2024/0367

Outline application for 1 custom/self build property with layout considered at this stage

Shalom, 16 Ings Road, Wombwell, Barnsley, S73 0BP

SCALE	DRAWN	APPROVED	DATE
1:200@A1	RPD	RPD	JAN'24
JOB No.	DWG No.	REVISION	
RD0367	0021	B

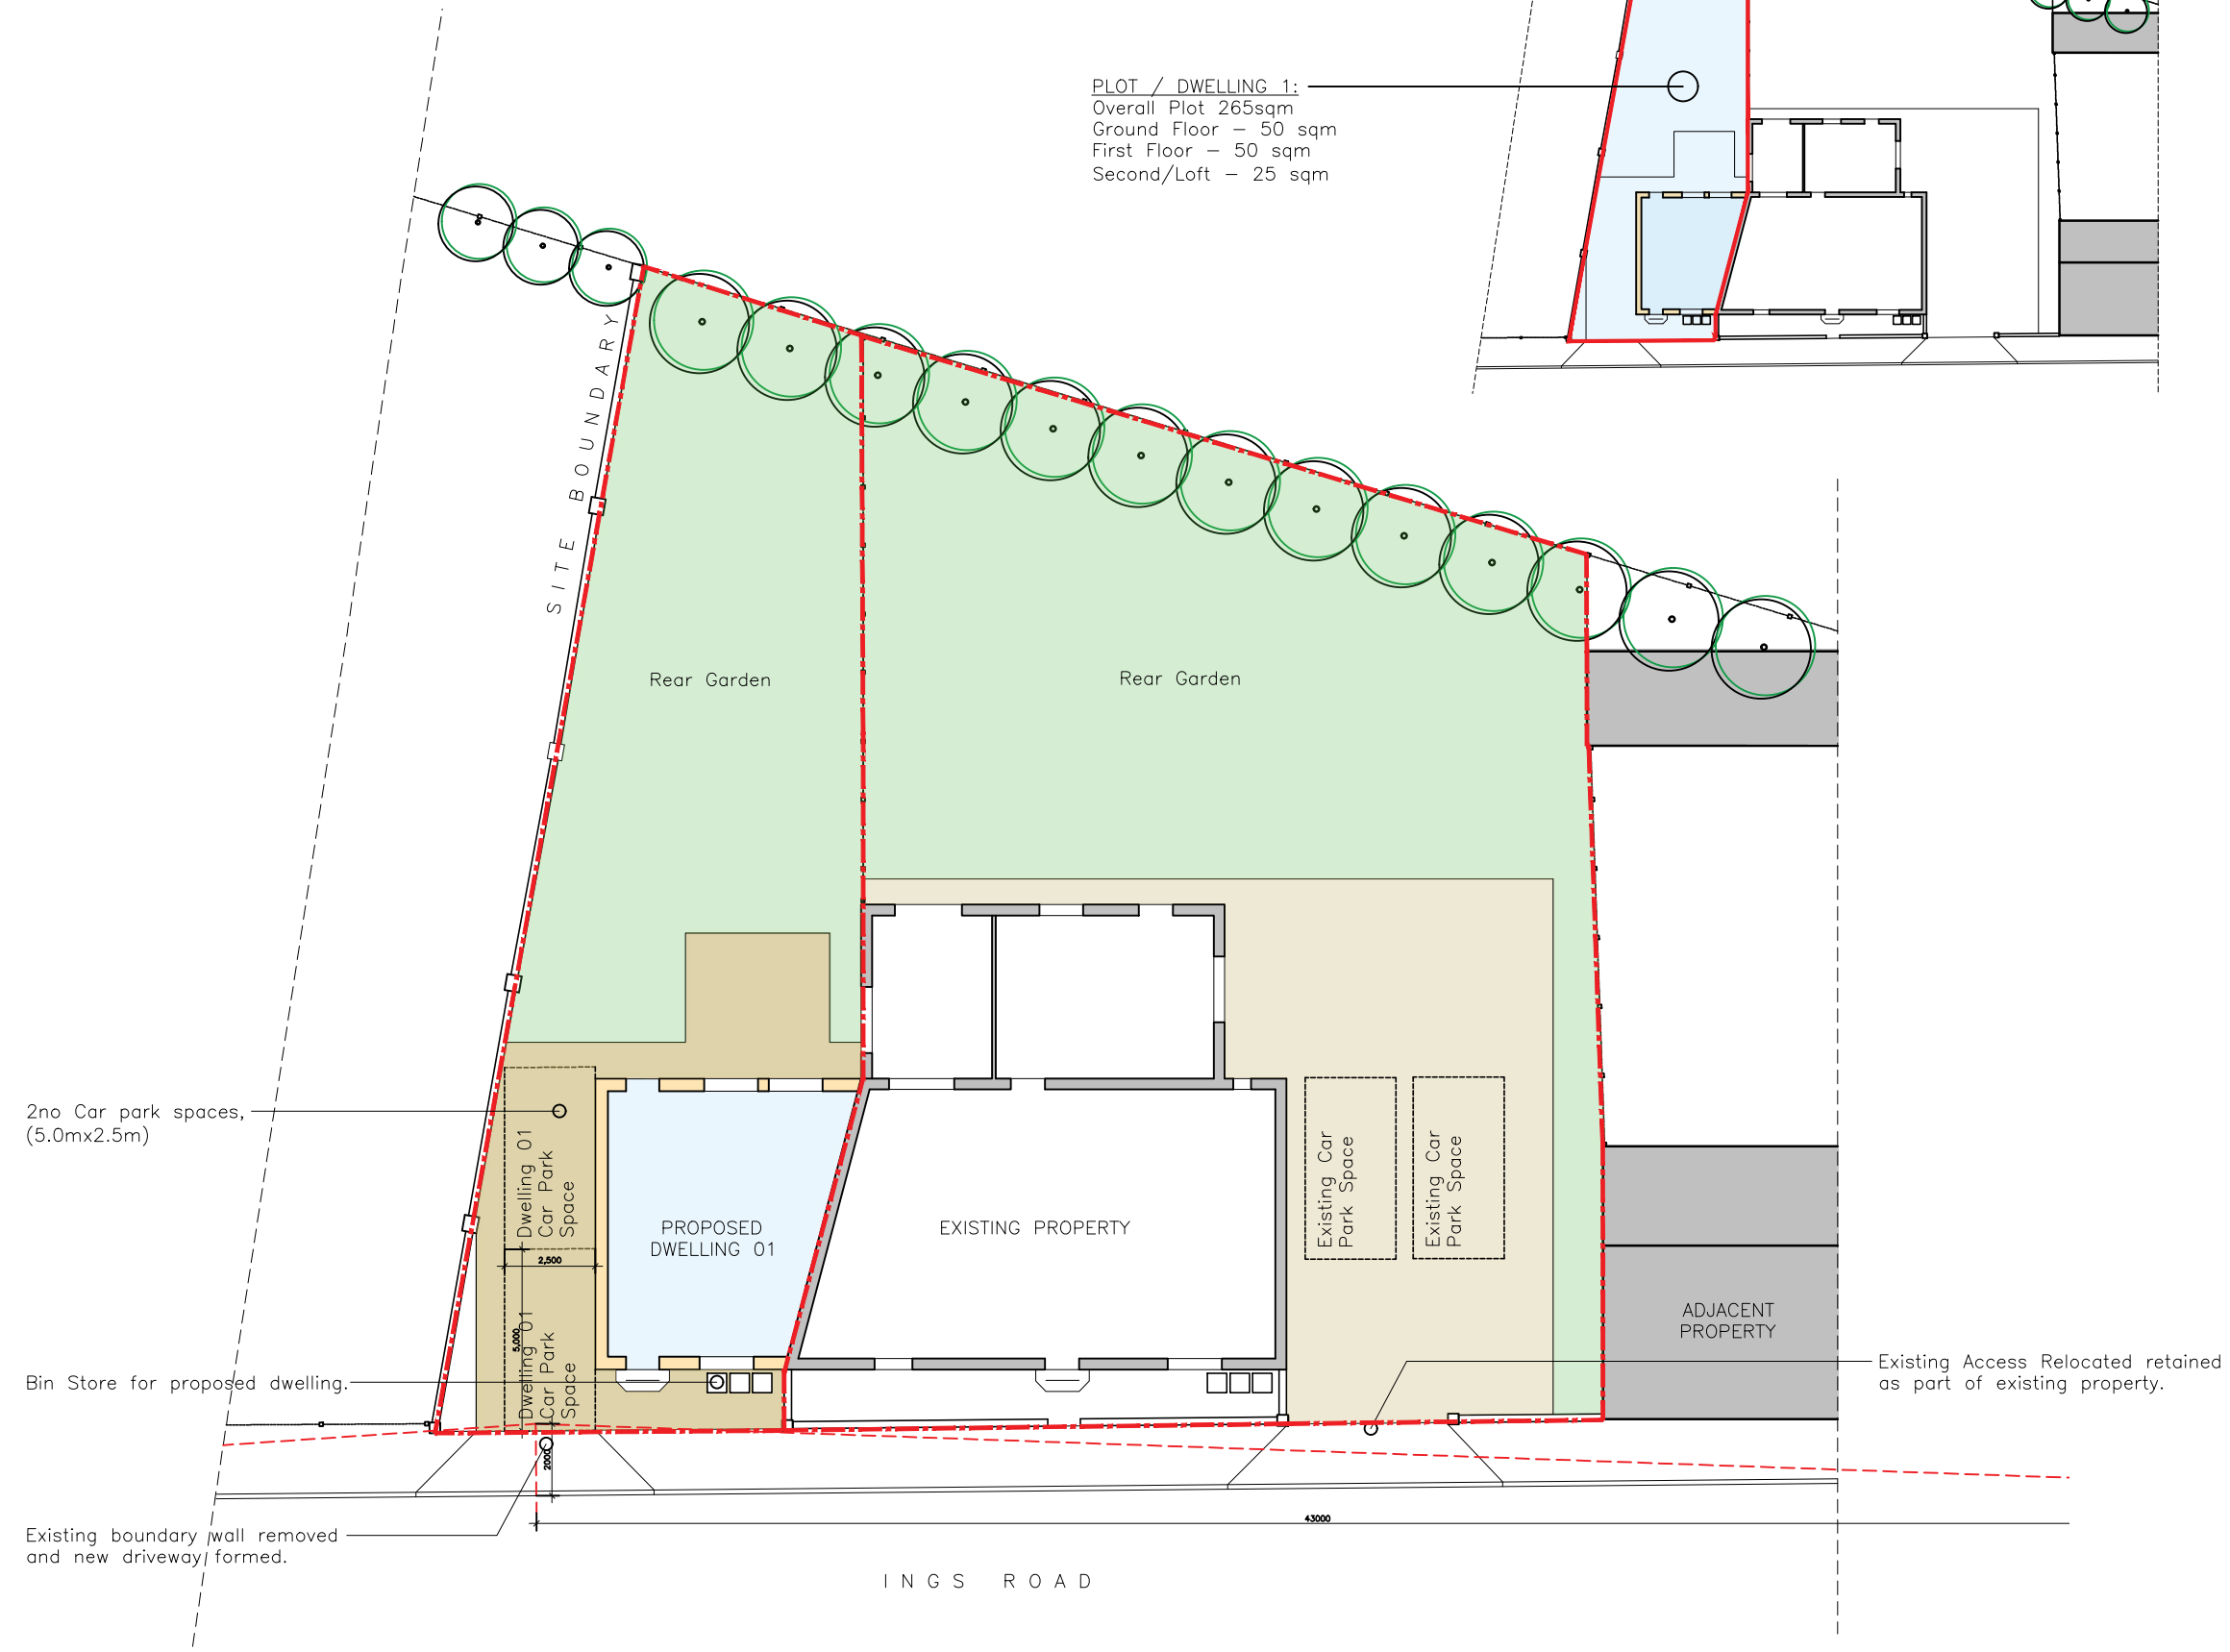
The plans have been amended and the number of dwellings proposed reduced. The Highways Officer has been consulted and states:- 'With reference to the further amended proposals shown on drawing no. 0021 Rev. B, I would now comment as follows:

The proposals now comprise the erection of one dwelling rather than the previously proposed two, the new dwelling is shown attached to the eastern side of the existing dwelling. It is proposed to create a new vehicular access point from Ings Road to serve the driveway of the new dwelling, adequate sight lines and pedestrian visibility splays appear to be achievable. The access and parking arrangements for the existing dwelling now remain largely unaffected by the proposals.

A bin storage area is shown to the front of the proposed dwelling which is satisfactory.'

Overall, the Highways Officer considers that the proposed additional dwelling will be unlikely to impact upon highway safety or the local highway network, subject to conditions. The proposal is considered to be acceptable in terms of highway safety in accordance with policy T4 of the Local Plan.
